WEST SUSSEX COUNTY COUNCIL CONSULTATION

TO:	Arun District Council FAO:Anita Gardner
FROM:	WSCC - Highways Authority
DATE:	9 March 2021
LOCATION:	Riverside Industrial Estate Bridge Road Littlehampton BN17 5DF
SUBJECT:	LU/42/21/PL Erection of 1 No. industrial unit (Use Class B2/B8), associated parking & landscaping. This site is in CIL Zone 4 (Zero Rated) as other development.
DATE OF SITE VISIT:	n/a
RECOMMENDATION:	Advice
S106 CONTRIBUTION TOTAL:	n/a

Proposed Site Plan

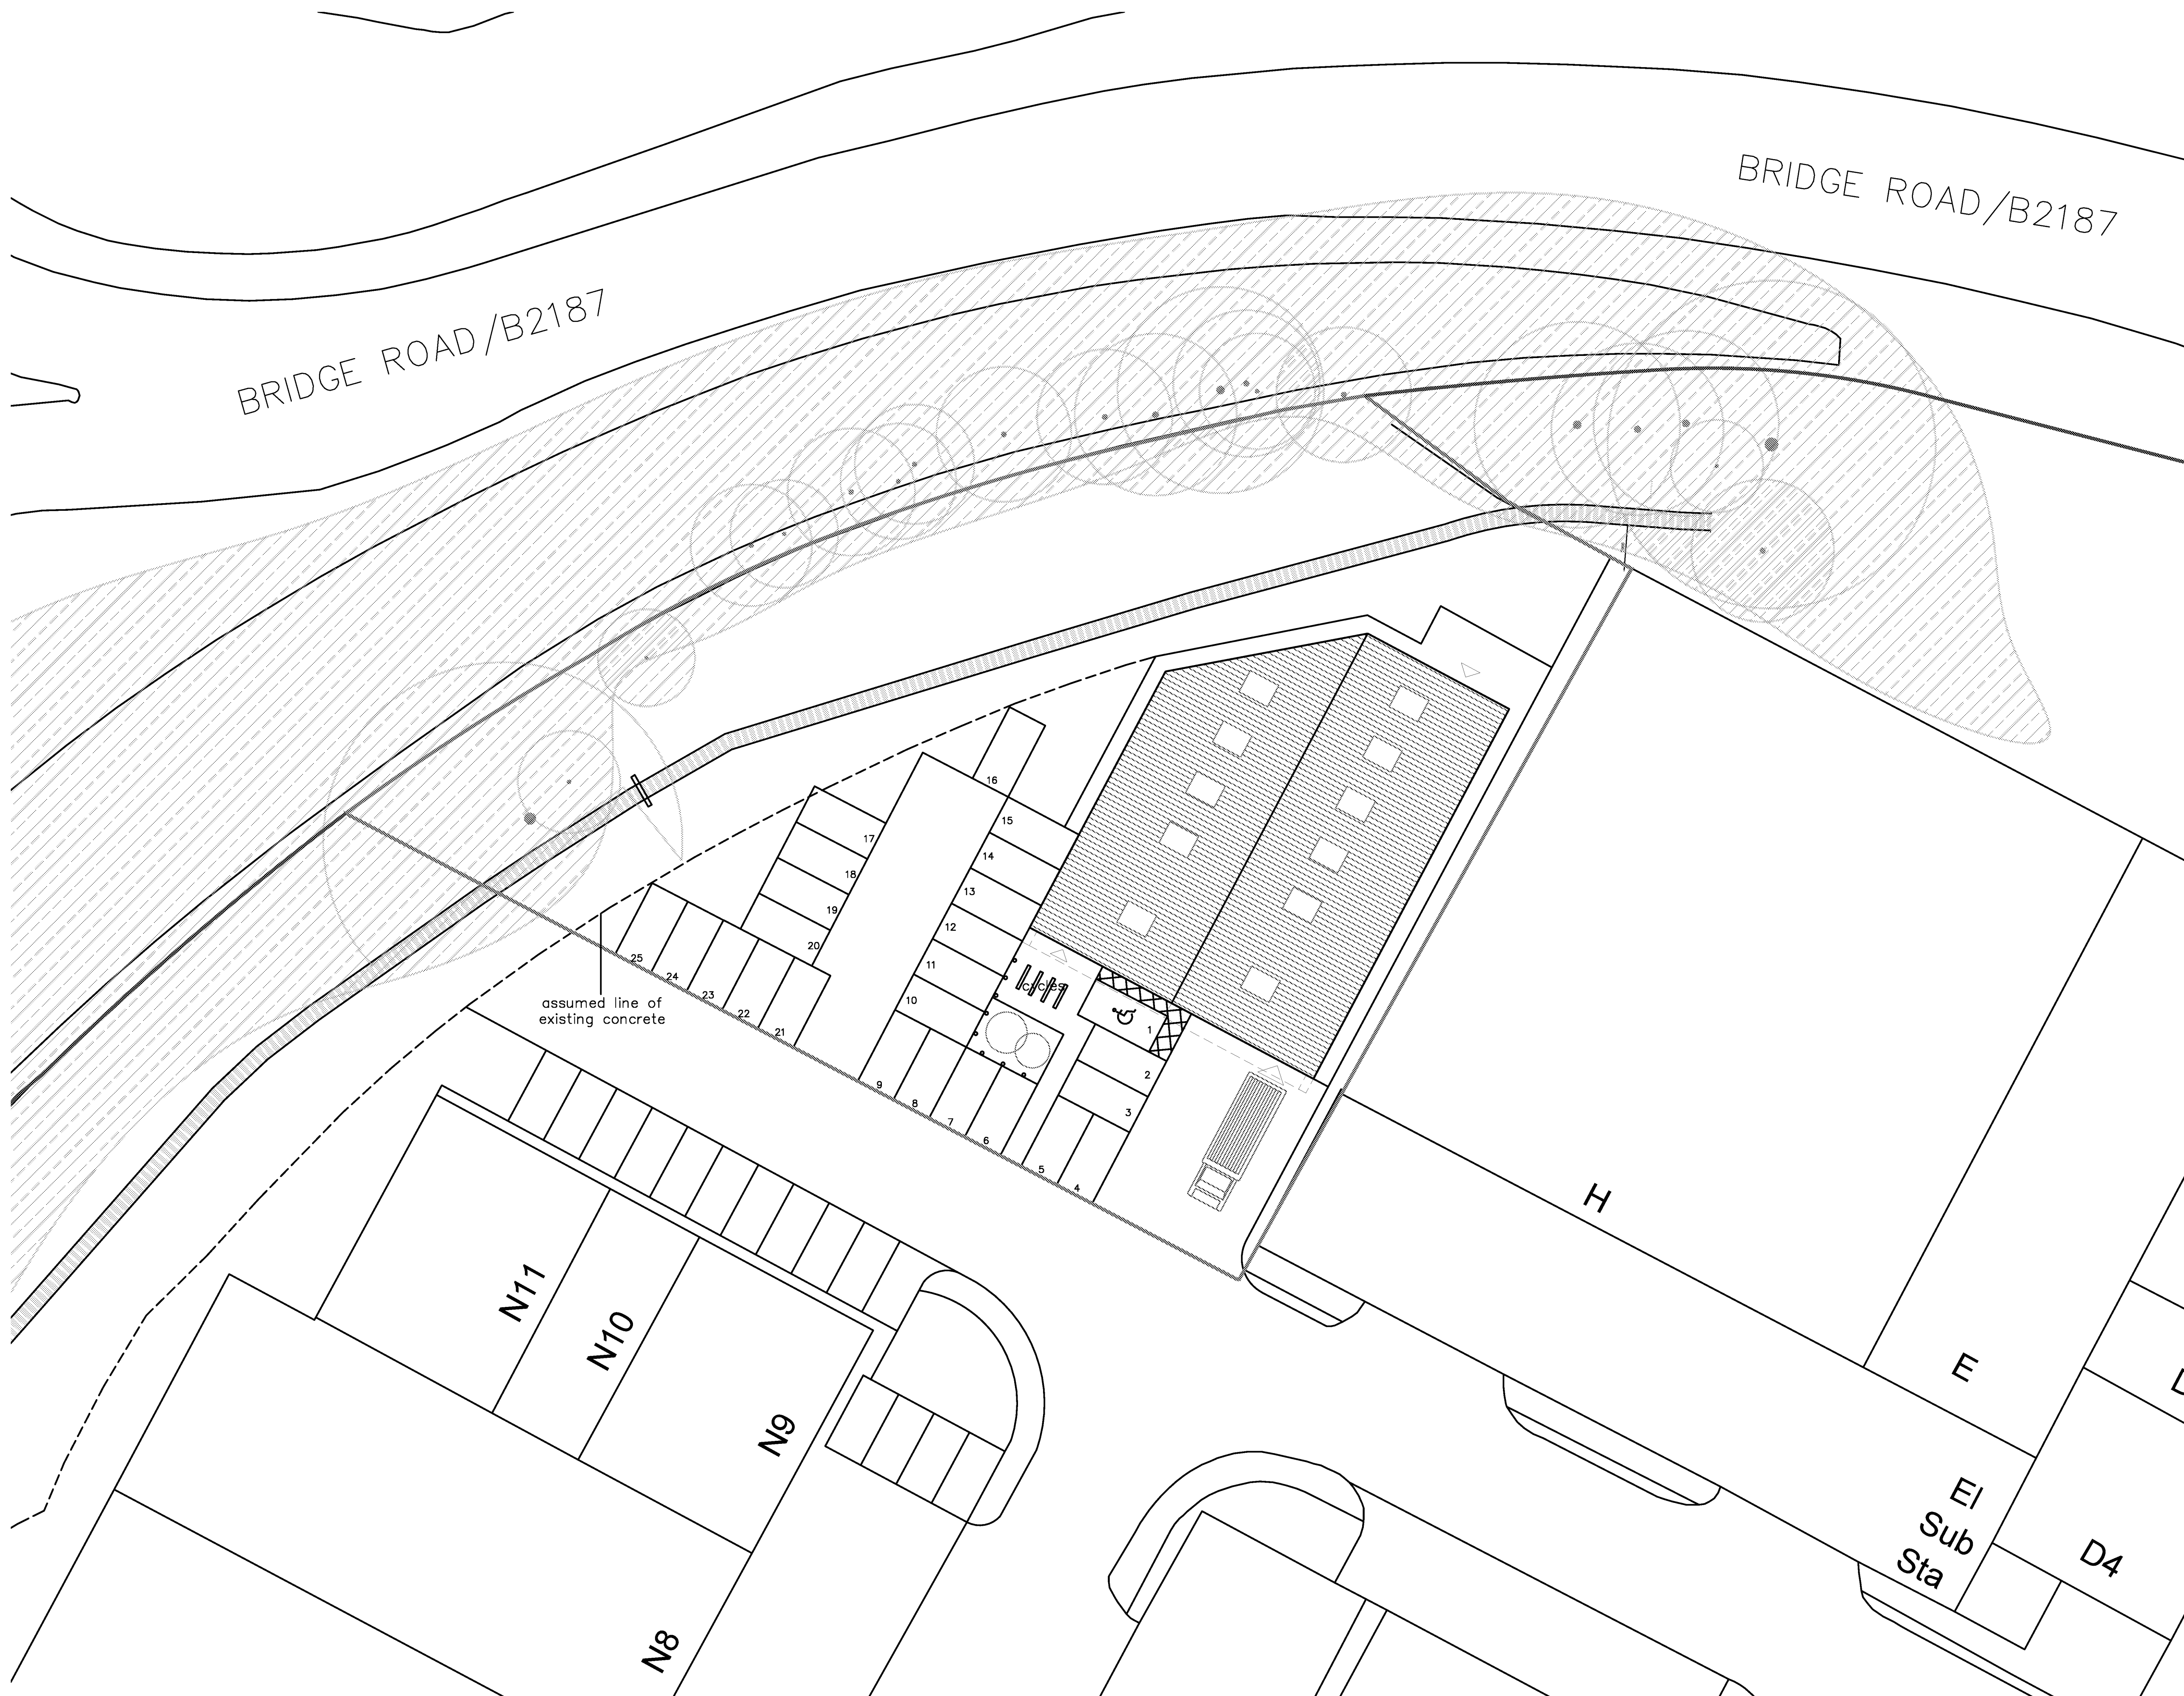
The proposed parking is considered acceptable. The LHA are not aware of that the previous use resulted in excess parking onto Bridge Road; it is considered unlikely that there would be an increase in on-street parking as a result of this proposal.

No part of the development shall be first occupied until the car parking has been constructed in accordance with the approved site plan. These spaces shall thereafter be retained at all times for their designated purpose.
